### CITY OF ALBUQUERQUE

### RE: Stormcloud Units 4A & 4B Supplemental Calculations Engineer's Stamp Date: 03/13/2018 Hydrology File: H09D022A

Based on the information provided in the Drainage Report Supplement received on 3/14/2018 the above-referenced application is approved for Work Order and Grading Permit.

POND SHALL BE CONSTRUCTED WITH WORK ORDER PLANS
FIRST FLUSH POND
SCALE: 1"=20'

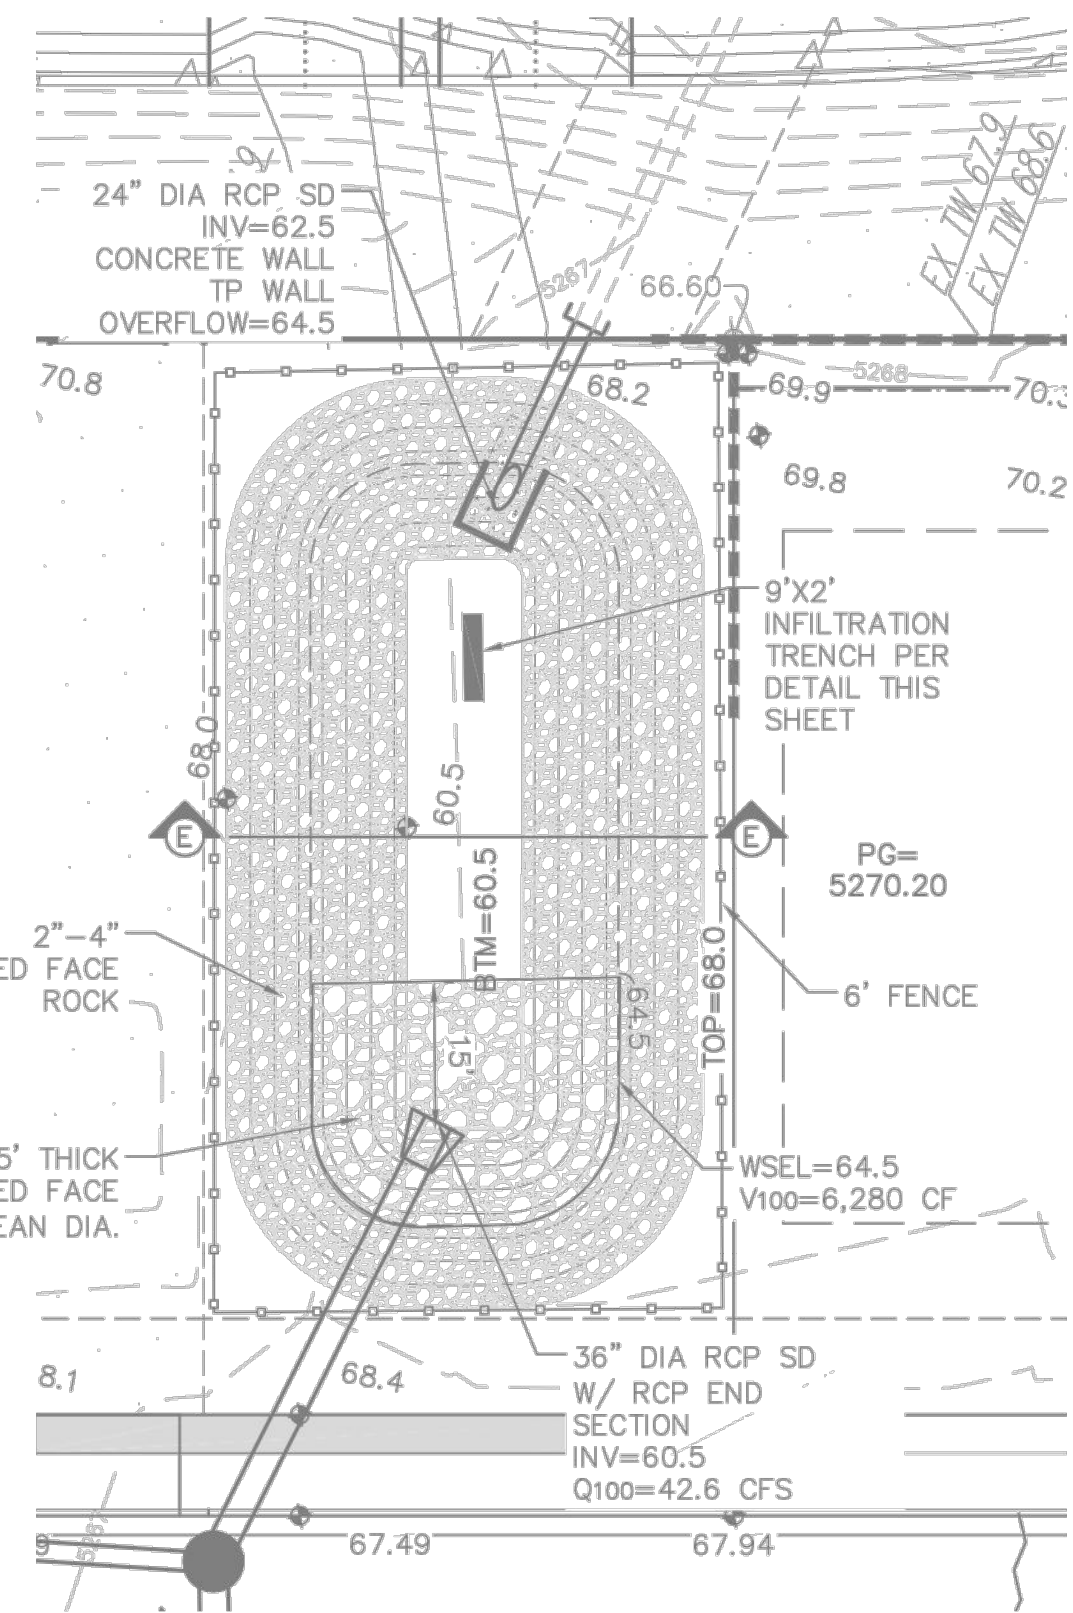
PO Box 1293 Prior to constructing the additional grading in the Unit 4A pond please submit shop drawings with sections showing horizontal and vertical dimensions to the property line and the fence and materials specifications to DRC. Please copy both AMAFCA and Hydrology with the shop drawings and sections.

Please ensure that the heightened Berm between the AMAFCA ROW and the Water Quality Pond is compacted and has erosion control to prevent deterioration of the Berm surface.
